**Subject:** IOZ Design Review – 222 St. John Street (Maine Medical)  
**Written by:** Caitlin Cameron, Urban Designer  
**Date of Review:** Monday, July 2 2018

The proposed garage at 222 St. John Street for the Maine Medical Campus was reviewed for the Planning Board workshop by Caitlin Cameron, Urban Designer, Nell Donaldson, Senior Planner, Deb Andrews, Historic Preservation Program Manager, and Jean Fraser, Planner. This project is reviewed according to the adopted IOZ IDP and Regulatory Framework standards.

ROOF DECK PARKING LIGHTING STATISTICS:

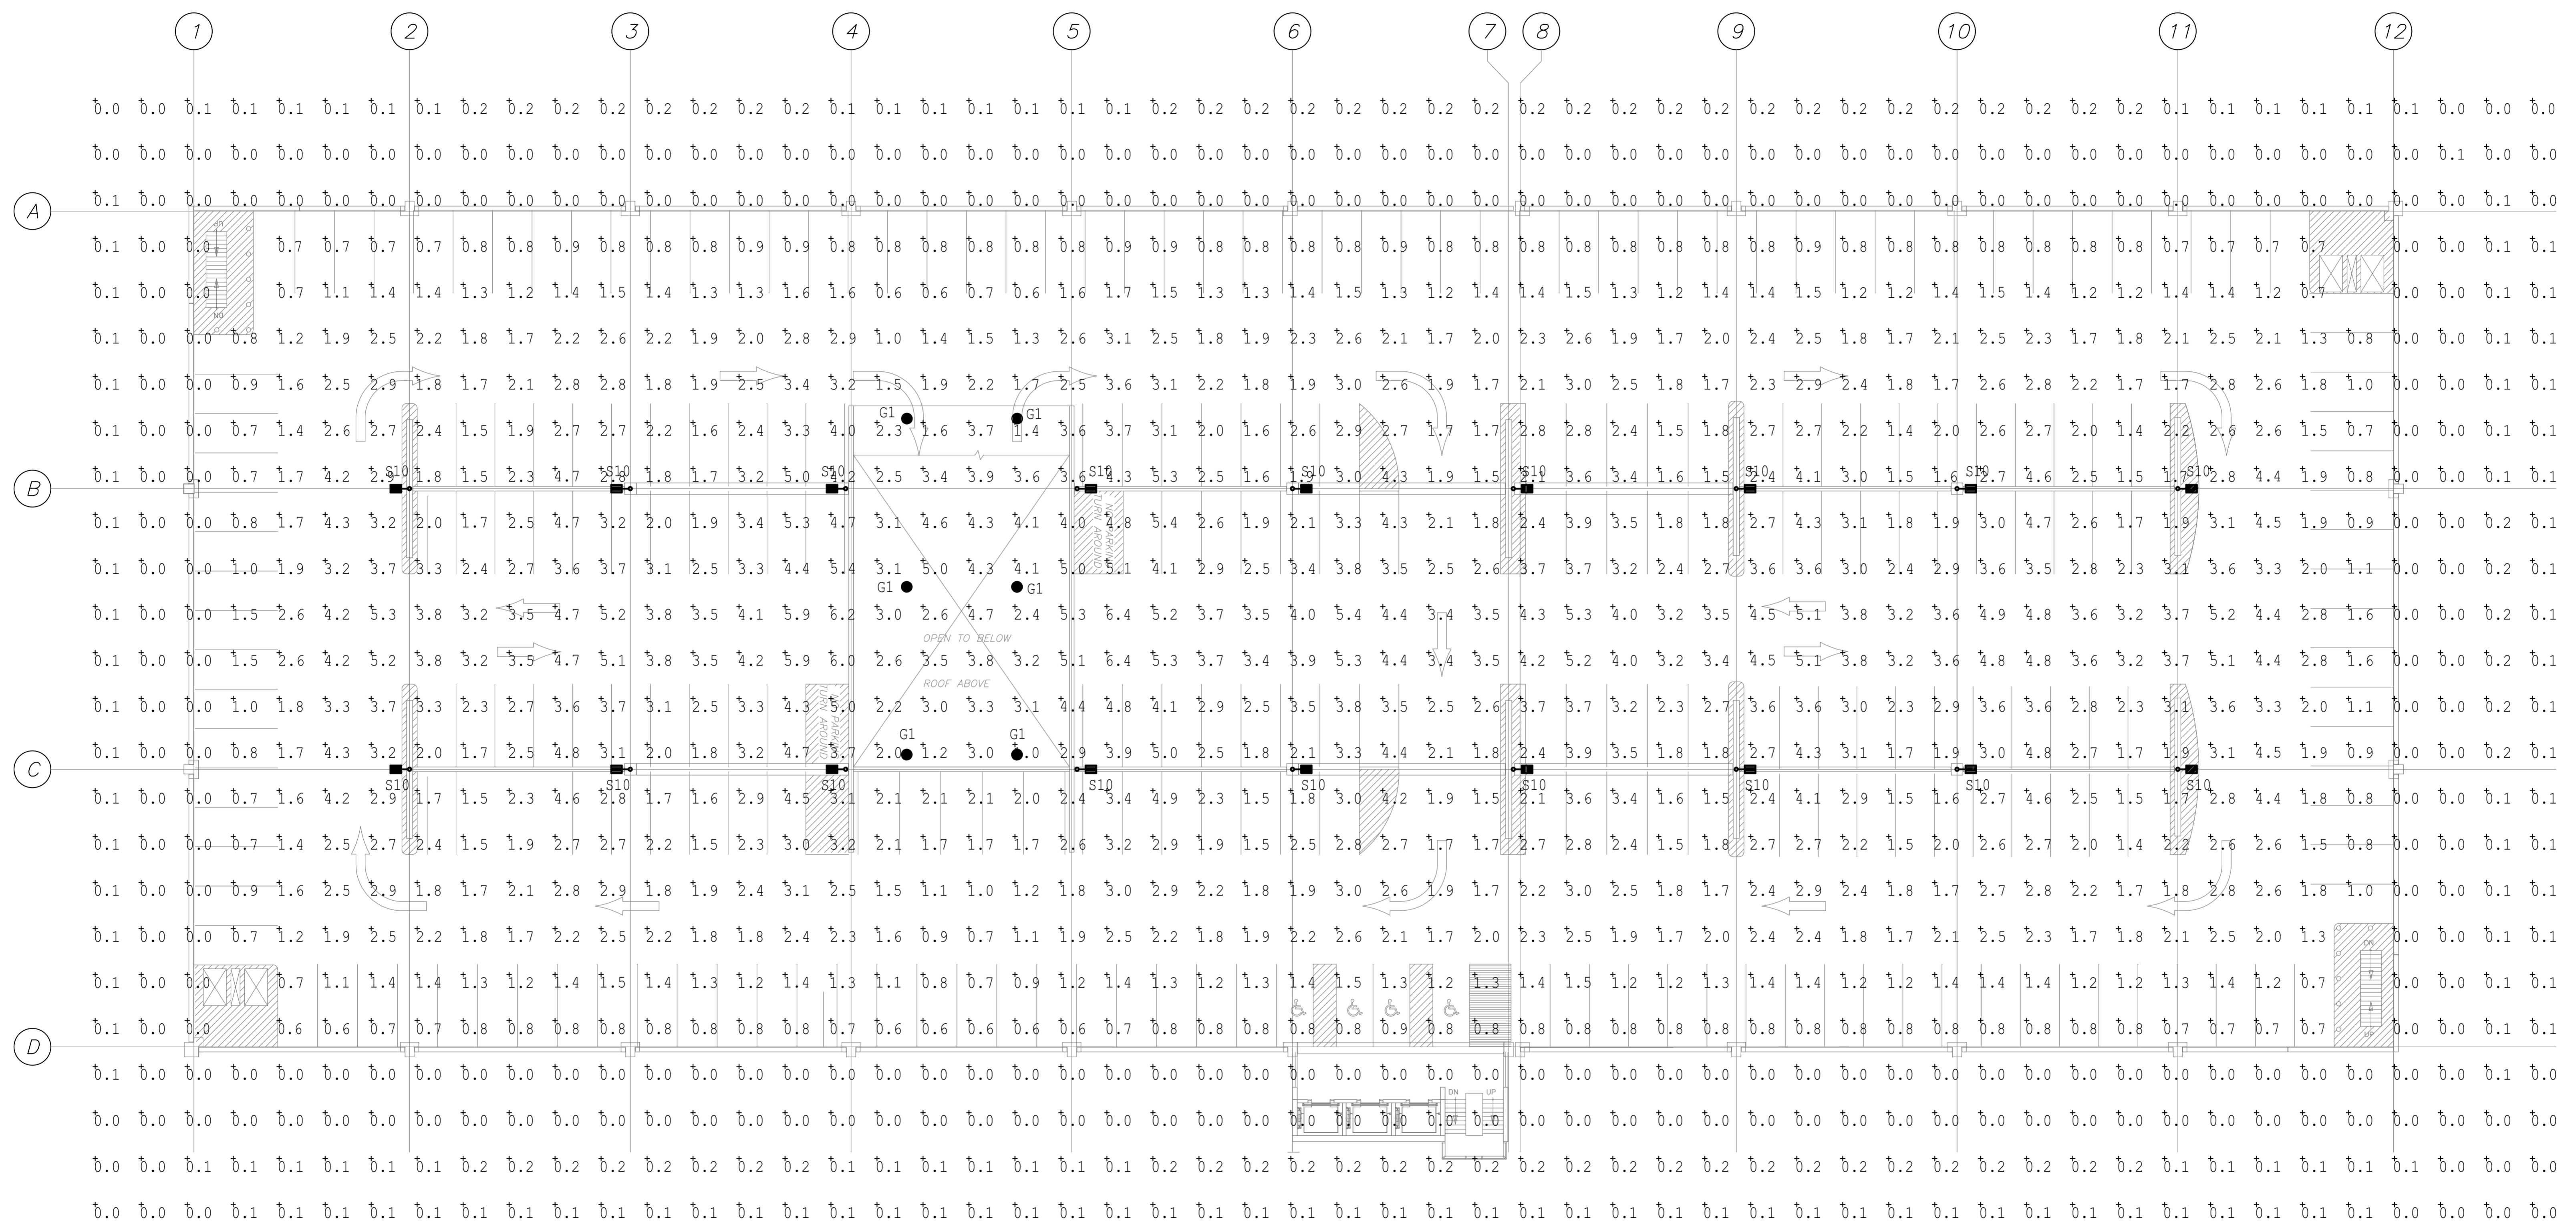
- **Are the ramp and circulation tower roofs adequately depicted in the renderings?** It is difficult to tell how visible these will be with the materials provided.
- **Concern about the visibility of the roof lighting poles and light levels, especially the impact on the Western Promenade.**
- The roofs at the top level are proposed to be glass to mitigate their visibility.

- **Clarify whether there is building lighting above the ground level**
- **Concern about light trespass** on neighboring residential properties and level of light visible from the Western Promenade at night. **More information is requested regarding the impact of site lighting from the long views, especially light trespass and visibility of the lighting on the upper stories and roof from the Western Promenade.**
- Street lighting in this location is standard cobra head – there is not a special lighting district on St. John Street. However, the pedestrian lighting within the Western Promenade, a connection between the new garage and the main campus, will be replaced with LED fixtures to be recommended by staff and the Historic Preservation Board and approved by the Planning Board at a future time.
